Our Ref: FP/42/17/A
Your Ref:

Town & Country Planning (Control of Advertisement) (England) Regulations 2007 (as amended)
Application for Consent to Display an Advertisement(s)

Development Various illuminated & non-illuminated signage at various locations within the site
Location The Southdowns 133 Felpham Way Felpham

Southdowns public house
133 Felpham Way,
Bognor Regis
PO22 8QJ

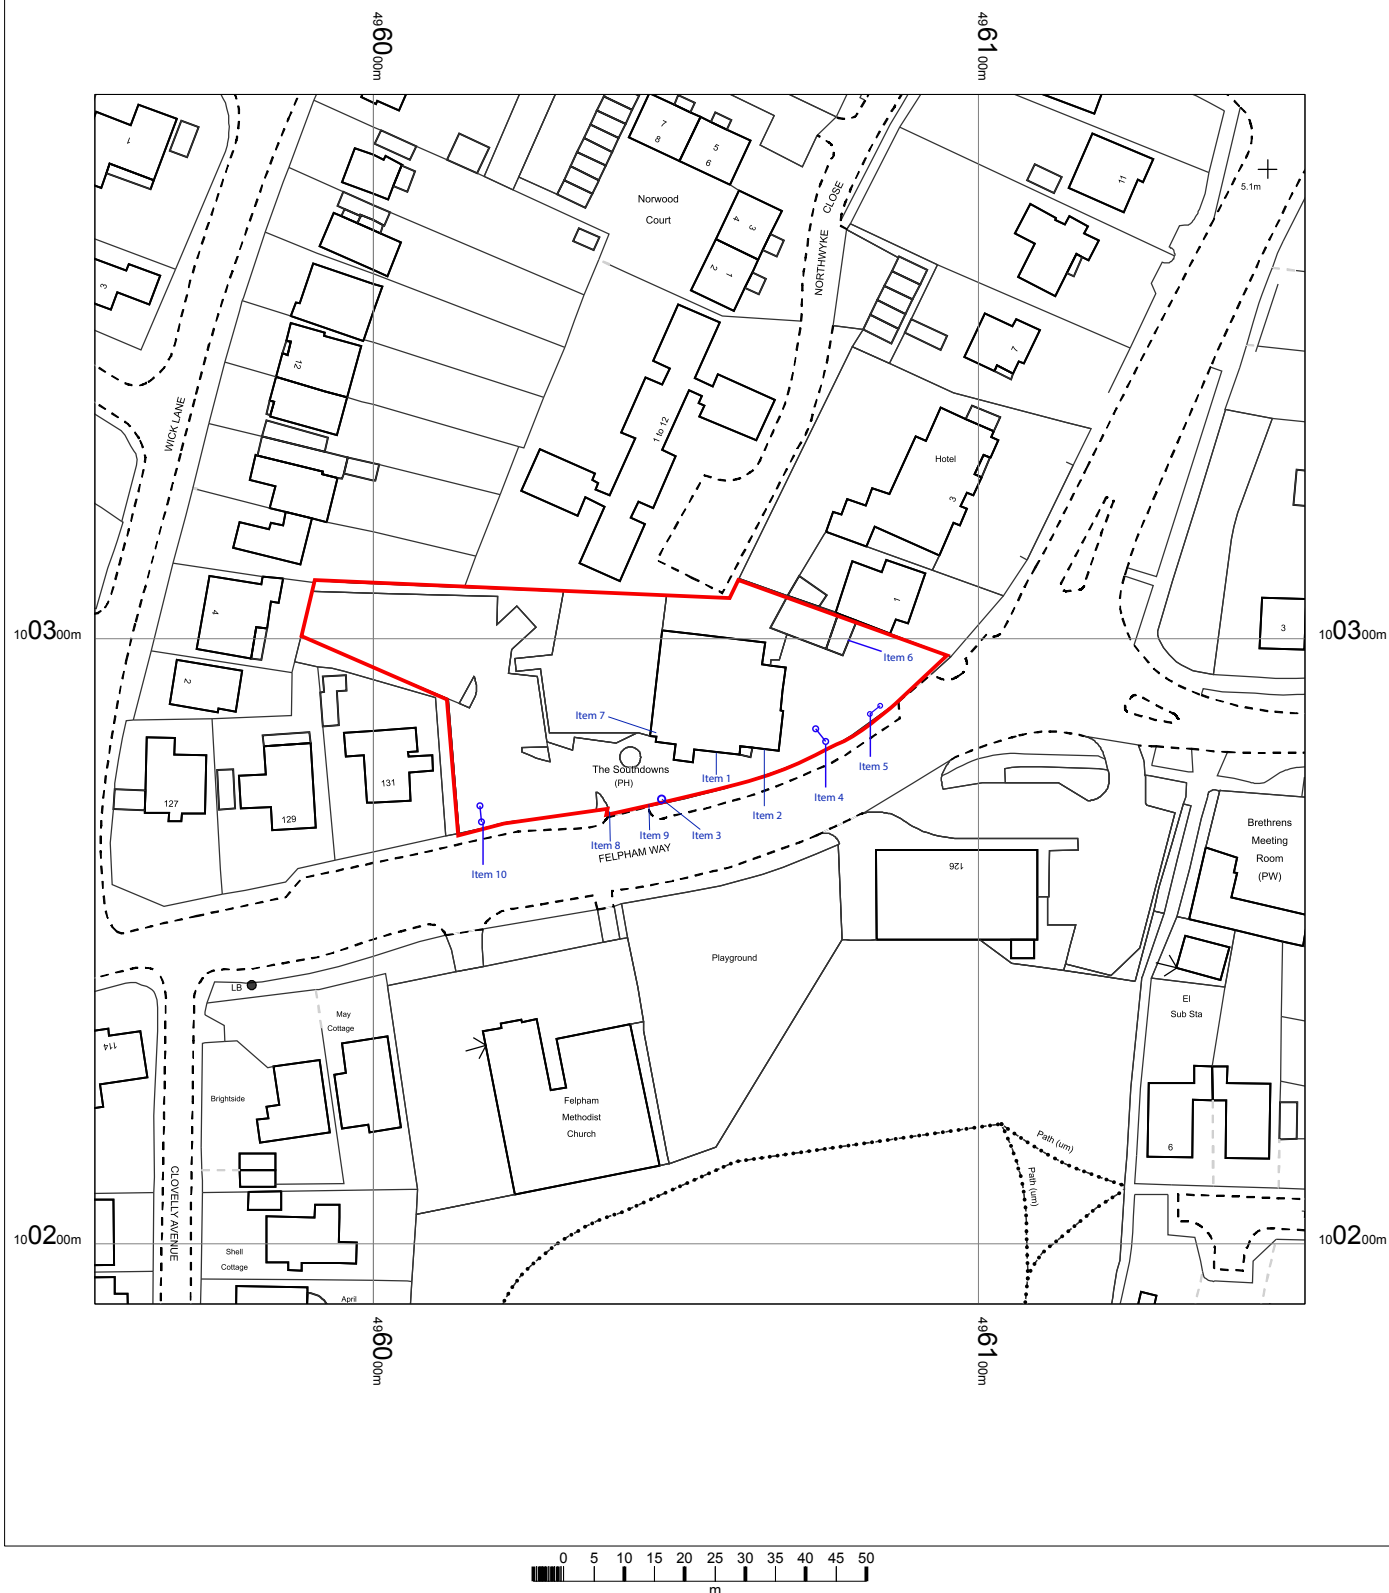
Location Plan

Please submit 1 electronic or 3 paper copies of a revised location plan at a scale of 1:1250 or 1:2500 for rural areas with all proposed signage clearly indicated. Further details of what must be included on the plan can be found in the National Validation Requirements.
